Appeal Decision

Appeal Ref: 6005469

10 Lawn Avenue, West Drayton UB7 7AQ

- The appeal is made under section 78 of the Town and Country Planning Act 1990 (as amended) against a refusal to grant planning permission.
 - The appeal is made by Nimesh Ghedia against the decision of the Council of the London Borough of Hillingdon.
 - The application Ref is 77359/APP/2025/2851.
 - The development is described on the application form as a 'new build single dwelling house'.
-

PROPOSED LOWER GROUND FLOOR

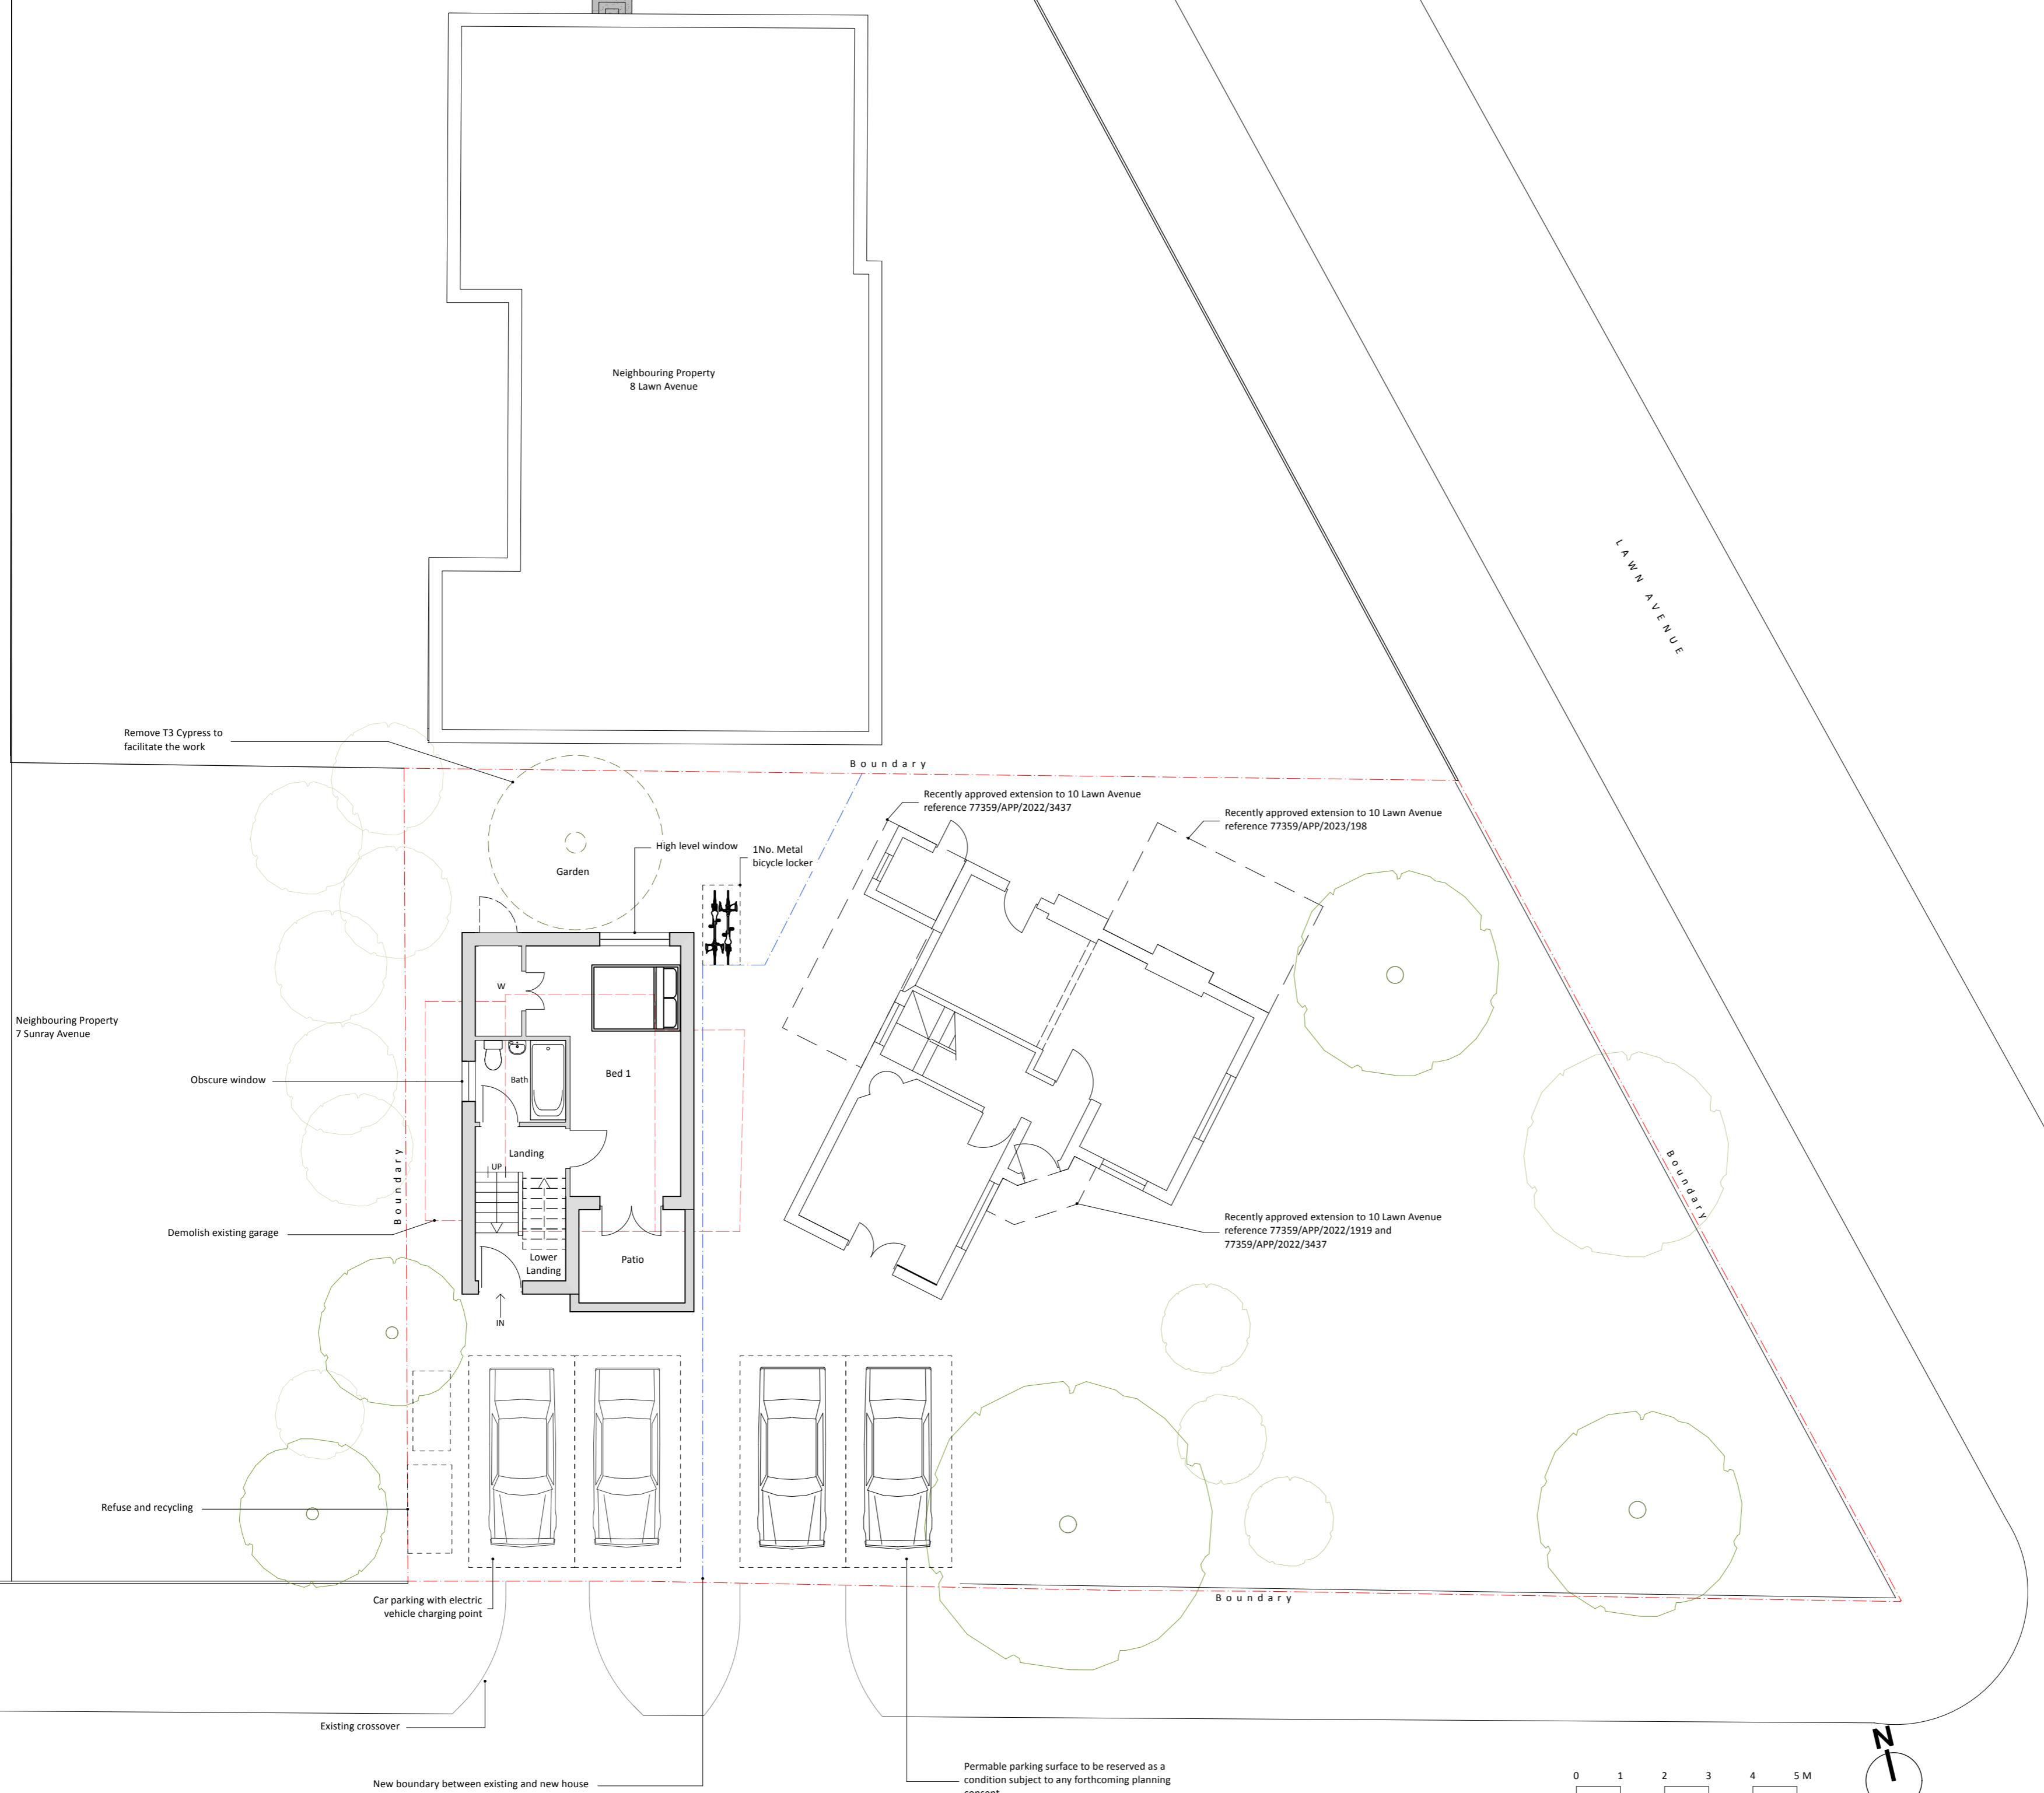
11. The proposal has a split-level arrangement and does not provide step-free access between floors. The parties agree that requirement M4(2) would not be met, and I concur. I note comments that the split-level design arises from the need to reduce the height, bulk, and visual impact of the development, and that non-compliance is therefore justified to avoid greater design harm. I also note that it is suggested that the dwelling could accommodate future adaptations, such as the installation of a platform lift or stairlift.

12. However, my assessment must be based on the proposal as submitted, which does not provide step-free access. I find that the failure to comply with requirement M4(2) arises from the constrained and contrived layout of the scheme, which seeks to accommodate development on a site of insufficient size to meet policy requirements. In these circumstances, the application of flexibility is not justified. The proposal therefore conflicts with Policy D7 of the London Plan, the requirements of which are set out above.

C03-A

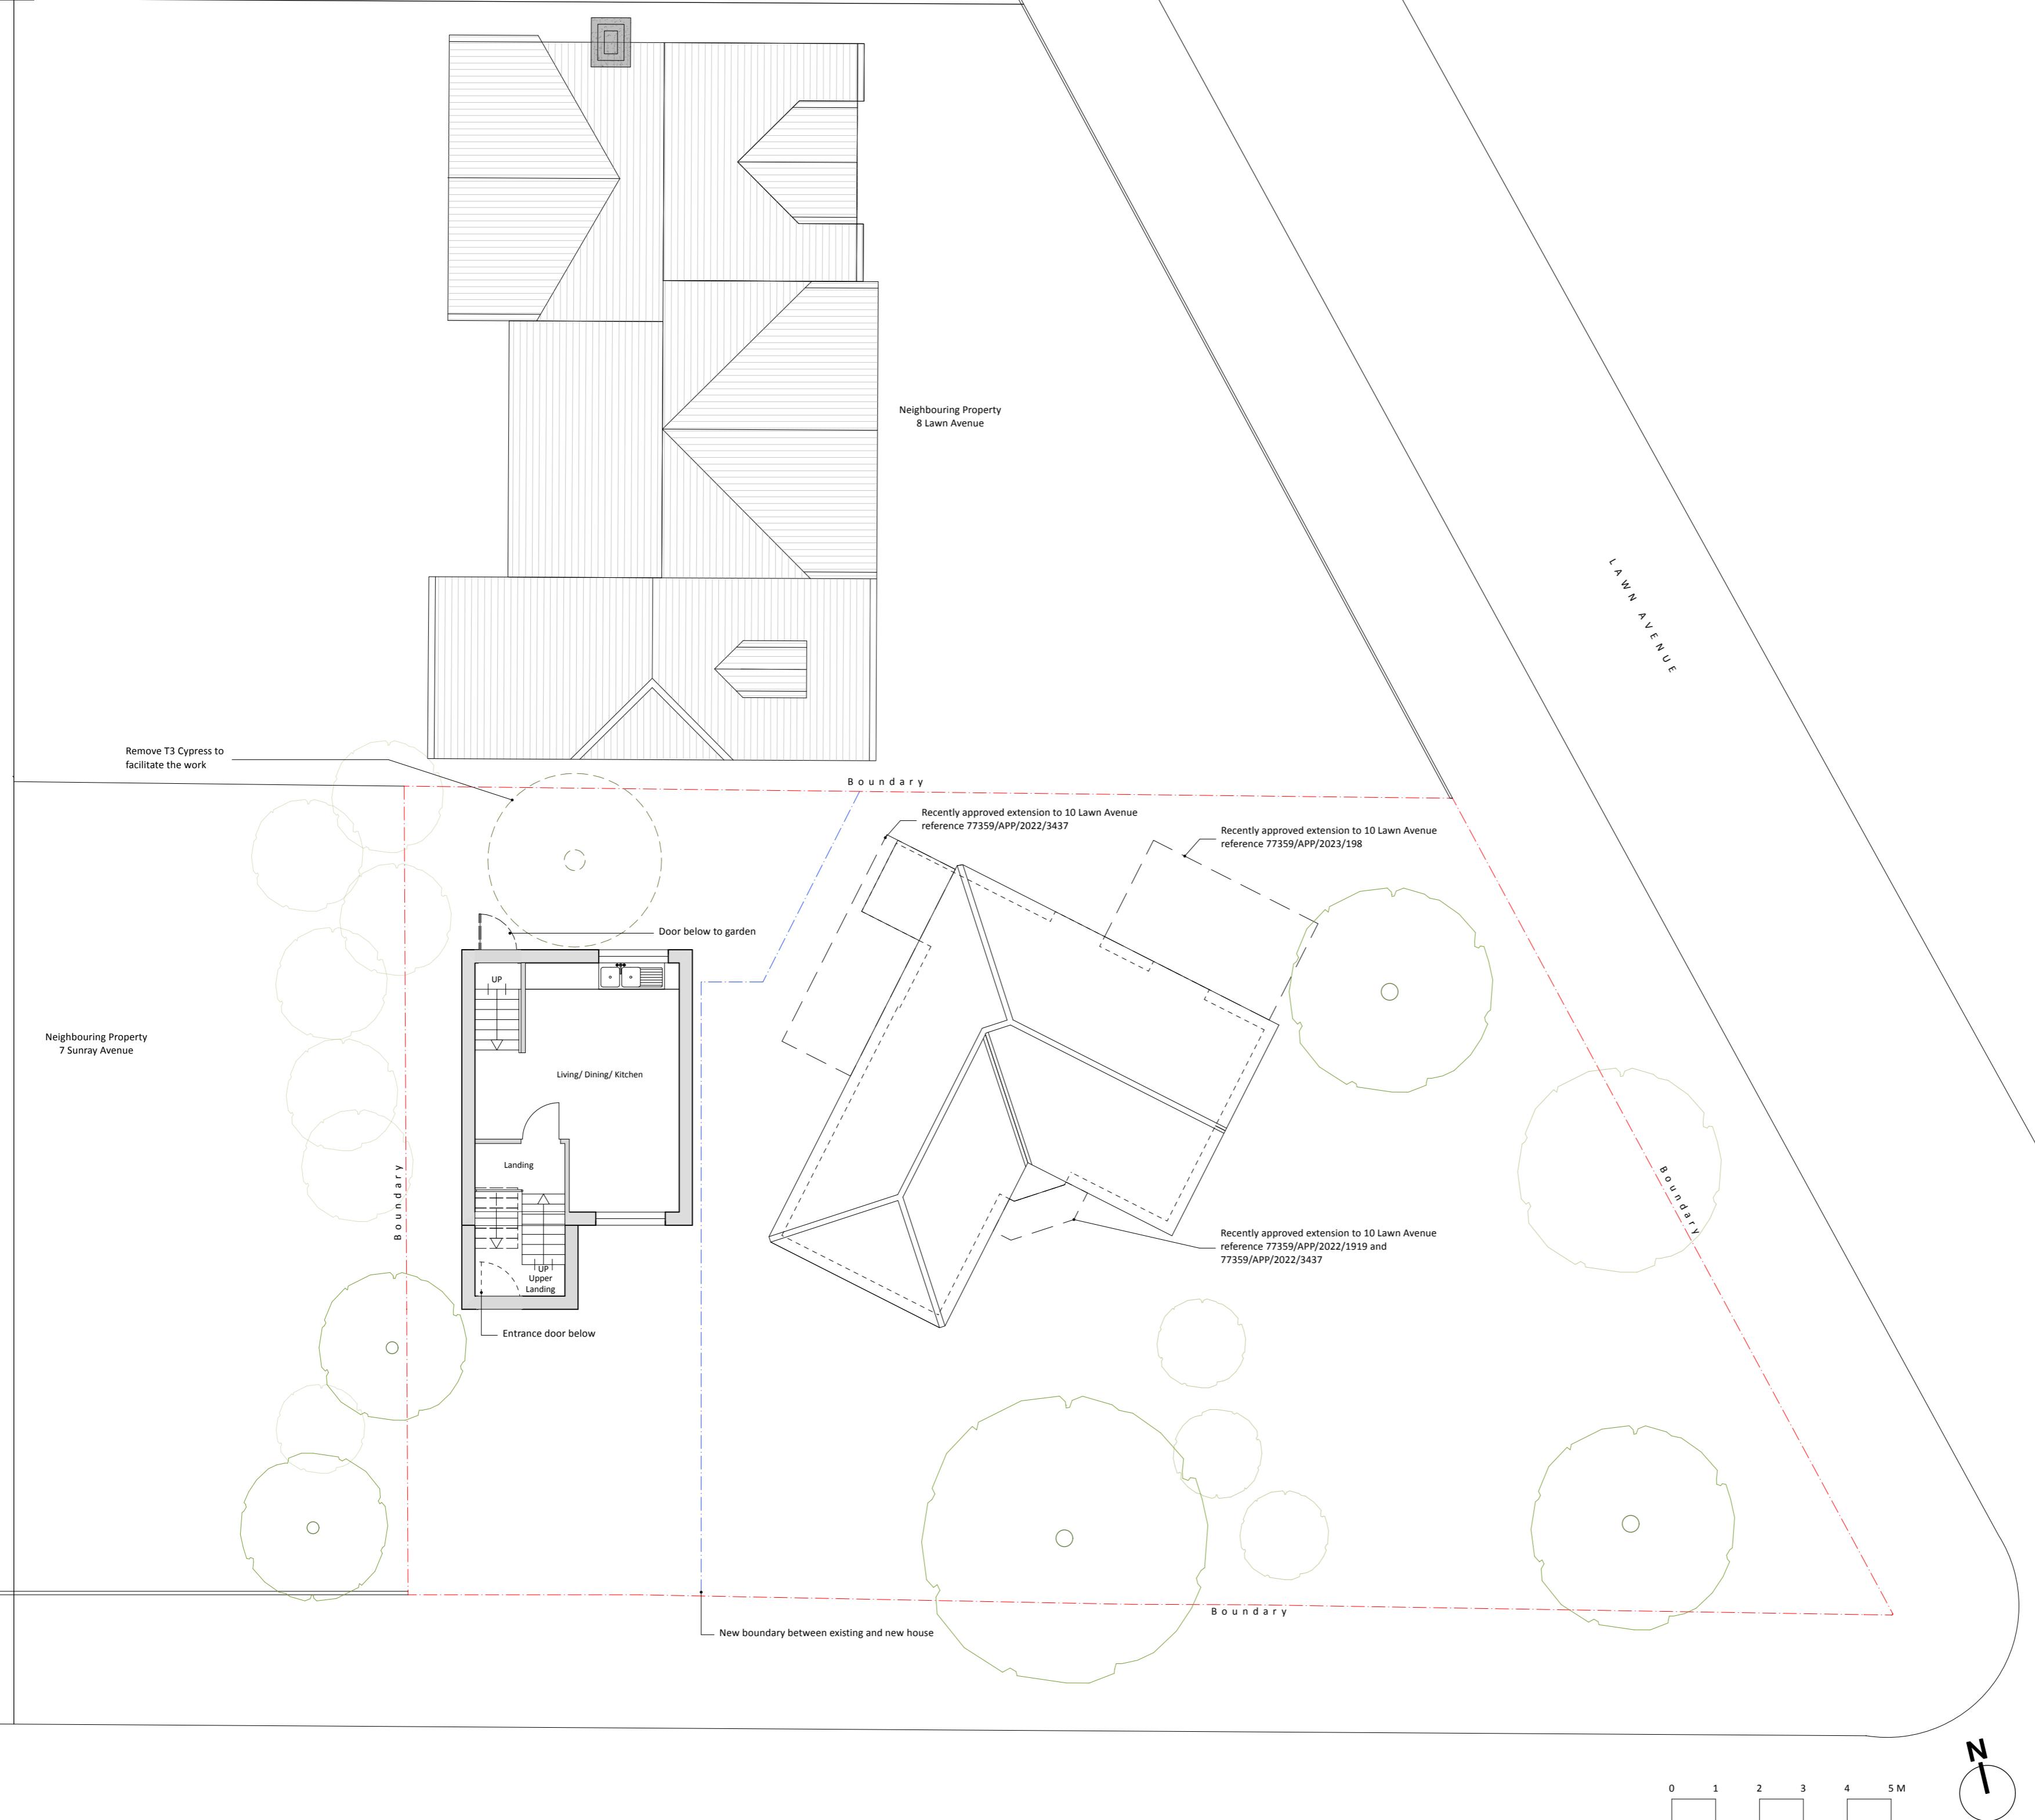
14. In respect of internal living space, while the combined living, dining, and kitchen area would not meet the minimum requirements of the Housing Design Standards London Plan Guidance (2023) (LPG), I note that the proposal would meet the overall gross internal area (GIA) standards of the London Plan. I note comments regarding the quality and usability of the proposed dwelling, particularly in relation to outlook, daylight, and sunlight to the bedroom. The bedroom would benefit from a window facing the rear garden and doors opening onto an external patio area. Although the outlook from these openings would be at a low level, I have no reason to conclude that they would fail to provide a reasonable level of outlook, daylight, or sunlight (accepting that such levels may be more attractive to certain occupants than others). Consequently, I find that the proposal would comply with Policy DMHB 16 of the Part 2 Plan and Policy D6 of the London Plan which, amongst other things and taken together, set internal space standards for new development and require the design of development to provide sufficient daylight and sunlight.

15. In respect of private external amenity space, I note that the proposal would meet the standards set out in Policy DMHB 18 of the Part 2 Plan only through the inclusion of a subterranean patio area. Given its limited size and restricted outlook, this space would not provide a good quality and usable outdoor area. The rear garden would also be relatively small and enclosed by surrounding development, far more so than is the case of the prevailing layout. I was unable to identify any dwellings in the immediate vicinity with comparably limited arrangements as is proposed here. Furthermore, there would be overlooking from second-storey windows at No 10 into the proposed rear garden at relatively close proximity. While I note the suggestion that obscure glazing could be used as a mitigation measure, it is possible that this could impact upon living conditions within the affected rooms of No 10.

C10-A

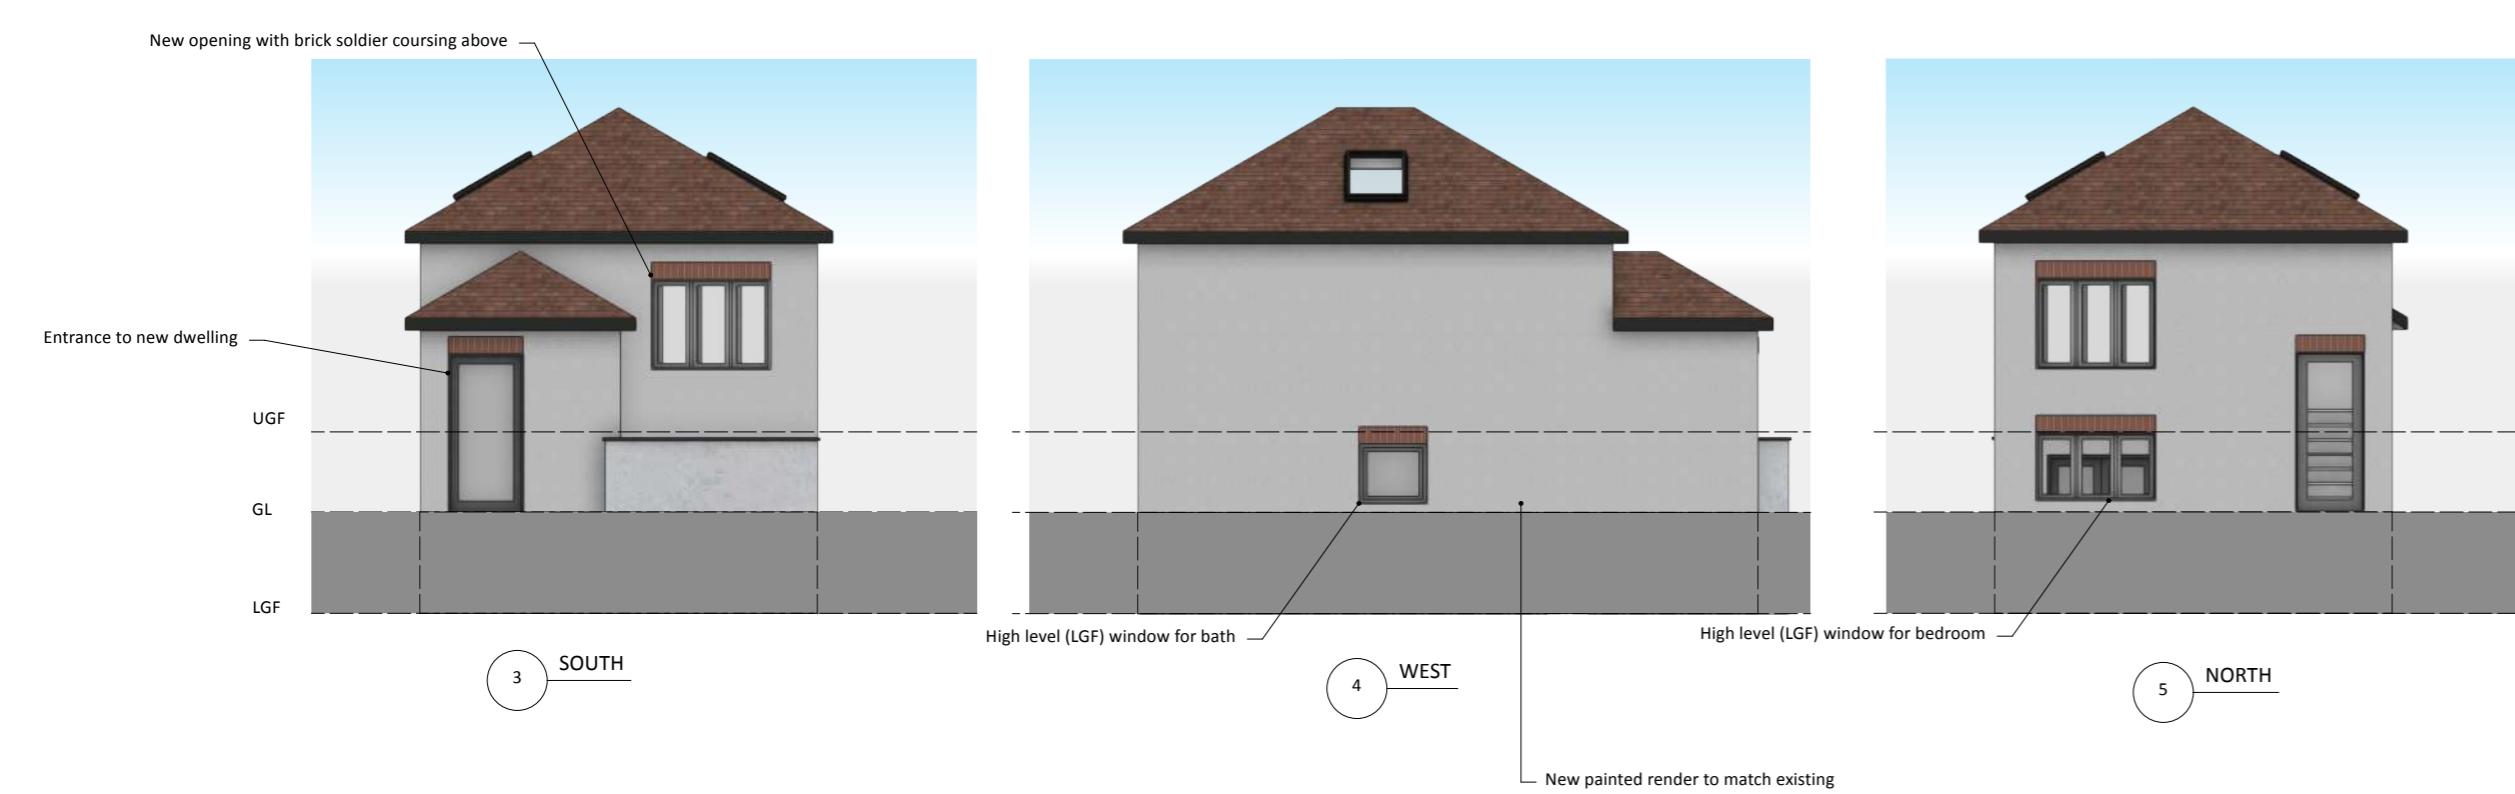
4. While there is limited uniformity in the detailed design of dwellings along the street, the proposed dwelling would be markedly smaller than surrounding properties, occupying a narrow plot with significantly less rear garden space and a smaller front garden and driveway. Although the proposed dwelling has been designed to appear subordinate to the existing property, it would nevertheless constitute a separate residential unit rather than an incidental domestic outbuilding. Given its form, associated parking provision and defined plot, it would be readily perceived as an independent dwelling within the street scene. Consequently, the proposed development would appear incongruous, cramped and contrived in the context of the prevailing pattern of development, causing harm to the character and appearance of the area.

5. The appellant states that the design draws on local features relating to rendering, roof form, and materials. Furthermore, the appellant states that the proposal would result in a significant visual improvement to the local street scene through the removal of the existing shed and garage, which are described as dilapidated. However, as ancillary structures associated with the main dwelling and garden, these buildings appear typical within this context. It is not unusual for such structures to exhibit signs of age, and their presence does not give rise to any material harm to the character or appearance of the street scene.
